**Outline Planning Application, Ribble Valley District
D3-12-0497 Strawberry Fields, Gisburn**

My comments refer to an Outline Planning Application with all matters reserved for future determination except for the means of access and layout. This Application is for a development of up to 21 residential dwellings, incorporating 14 properties for market sale and 7 affordable properties on land at Strawberry Fields, Gisburn.

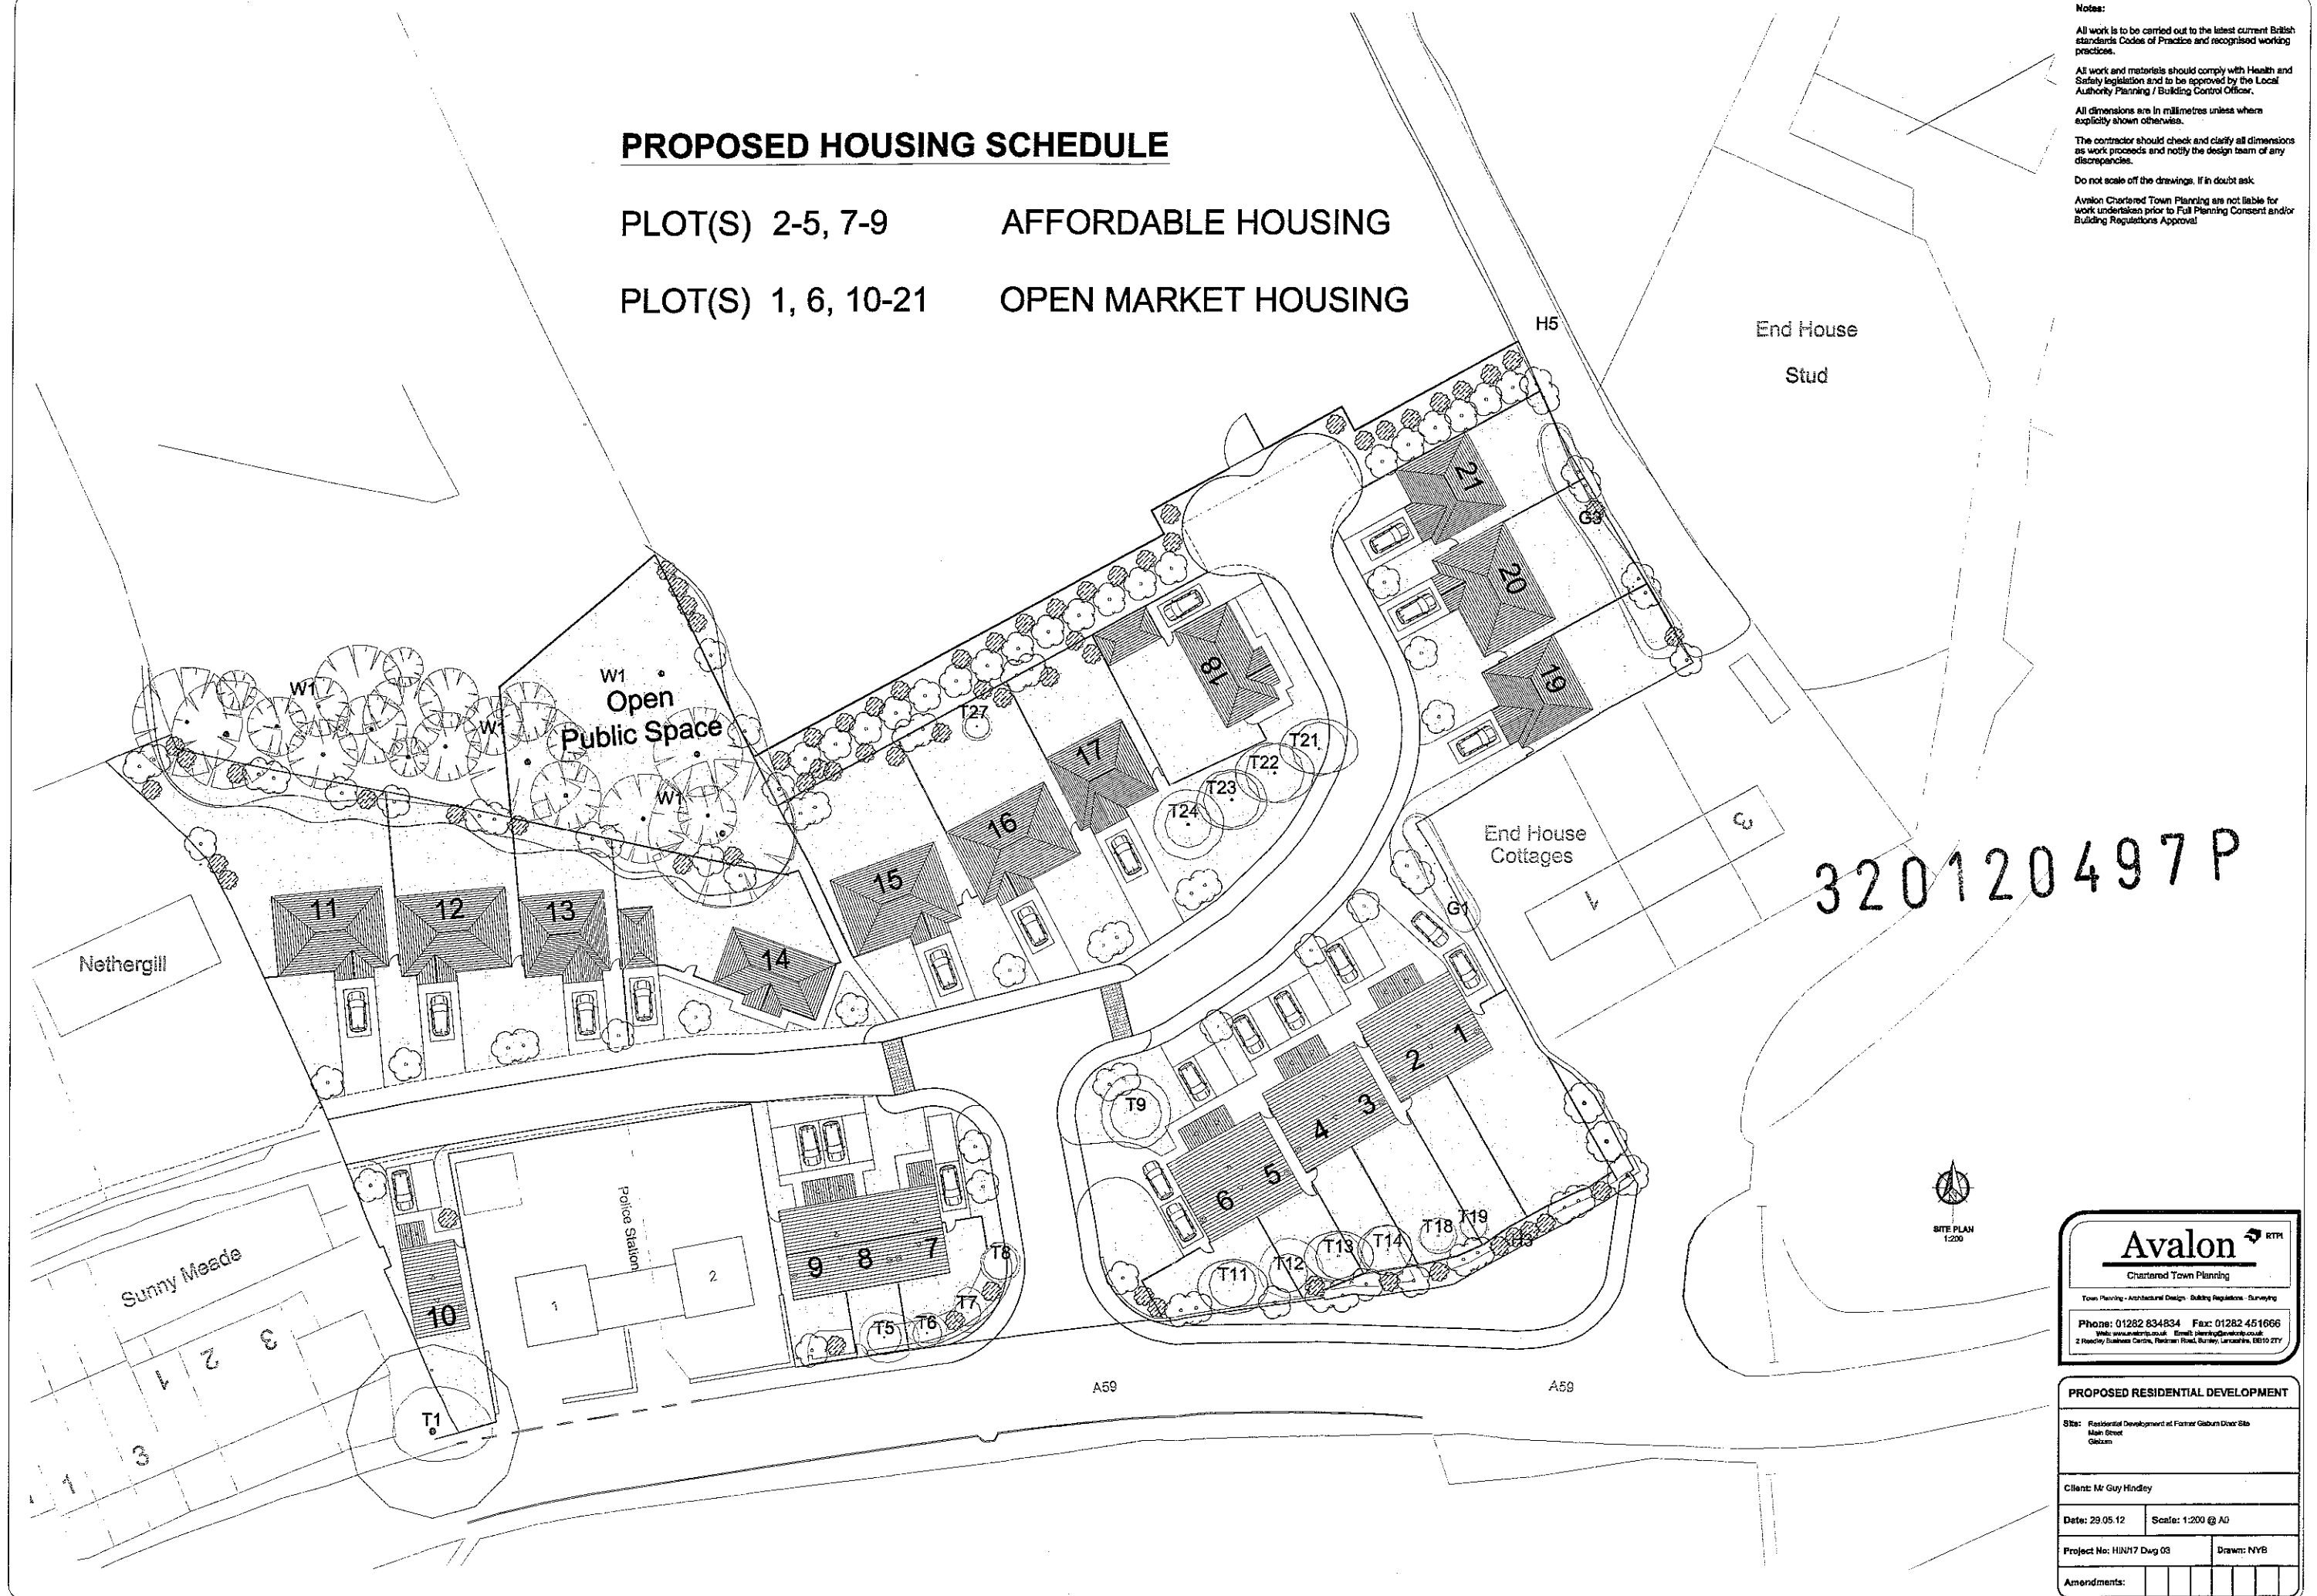
The location of the vehicular access to the site is retained as existing from the previous development on this site. However, the site plan (Drawing HIN/17 02) indicates that there will be the provision of additional footway links, of minimum width 1.8m, to either side of the access. This provision extends into the site but it is not clear from the drawing if this will provide a continuous link to all proposed properties, except along the south side of the access road at the back of the police properties and to the isolated development at Unit 10.

i. The proposed limits of adoption within the site are not clear. The construction of the new estate road between the site and A59 Main Street shall be constructed in accordance with the Lancashire County Council Specification for Construction of Estate Roads and to comply with Manual for Streets (1 & 2).

ii. The provision of a turning head to the north east of the site is welcomed. However, there is no similar provision to the west of the site where the new carriageway links to an unmade track serving existing properties.

As a result there is no safe location for turning within the proposed development and my concern is that motorists are likely to turn at the most accommodating access in this vicinity, which would be at Nethergill. While there will be a clear delineation in the limits of the existing track and the new carriageway, turning provisions need to be provided within the limits of the proposed development site.

There are 42 spaces shown on the application and the applicant has assigned two spaces to each property as a rudimentary means of determining an initial parking layout within the site.

However, until the house types and sizes have been identified, the appropriate provisions for individual properties cannot be reasonably determined and should be considered as a Reserved Matter.

1. The extent of the footway provisions within the site.
2. The lack of footway provision to Unit 10.
3. The proposed extent of any proposed highway adoption.
4. The provision of a turning facility to the west of the site.
5. Details of the distribution of housing types and sizes to assist with the determination of appropriate parking provisions.
